P22-2888

8 August 2024

Application Reference: 2024/0373

Re: The proposed erection of building for glass recycling; storage bays; office building, canteen and mess, new vehicular/pedestrian/cycle access with gatehouse, weighbridges and associated works including landscaping at Stairfoot Brickworks, Wombwell Lane, Stairfoot, Barnsley, S70 3NS.

Processing Building Section 1  
1:100

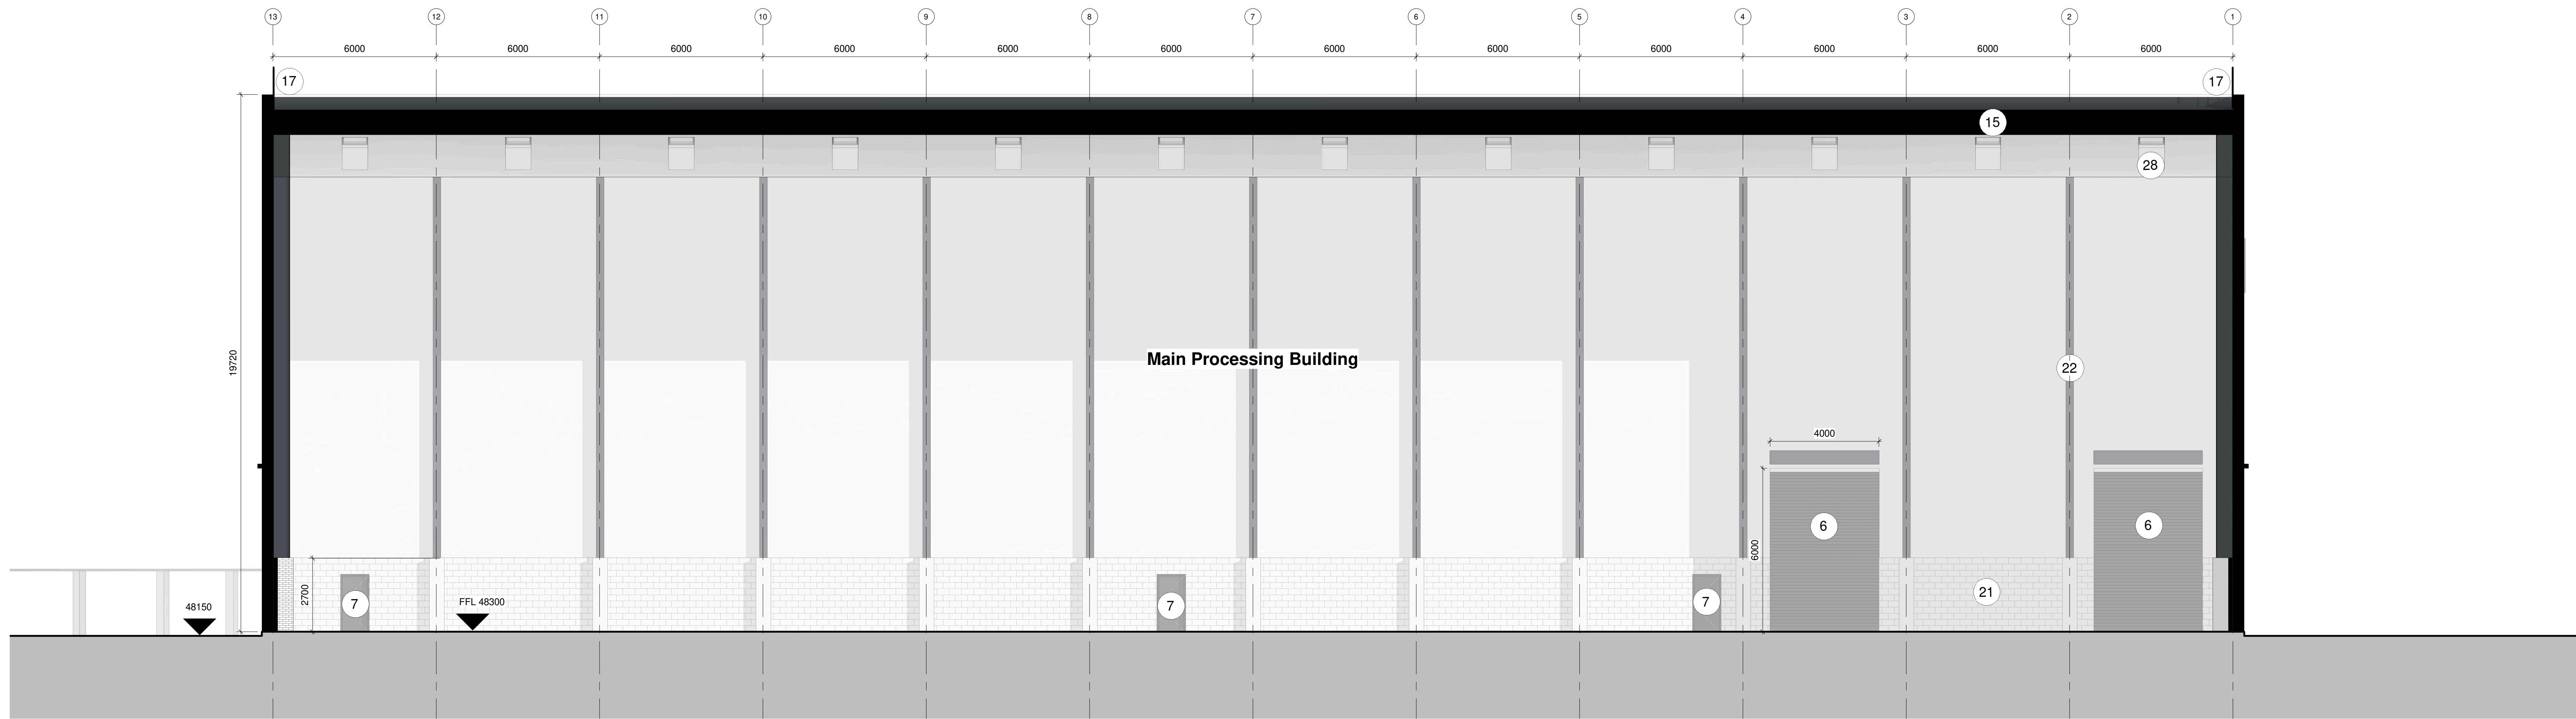
Justification for building height

Following our meeting dated 20th June 2024, the design team has reviewed the height of the building and ways in which the internal equipment and overall operations can be reorganised. Consequently, the height of the building has been reduced to 15.7m above ground level (from that originally proposed at 19.7m above ground level). This accounts for the height of equipment to be located within the building, alongside 'working at height' buffers. See drawing ref. 965-D5A-XX-XX-DR-A-0006-Processing_Building_Proposed_Elevations Rev.CO2 for more details.

Additionally drawing ref. 965-D5A-XX-XX-DR-A-0007 Rev.CO3 outlines the internal processing dimensions and the lorry tipping height, in which justifies the 15.7m building height.

The building cannot be made any smaller, otherwise it will not be able to serve its intended purpose.
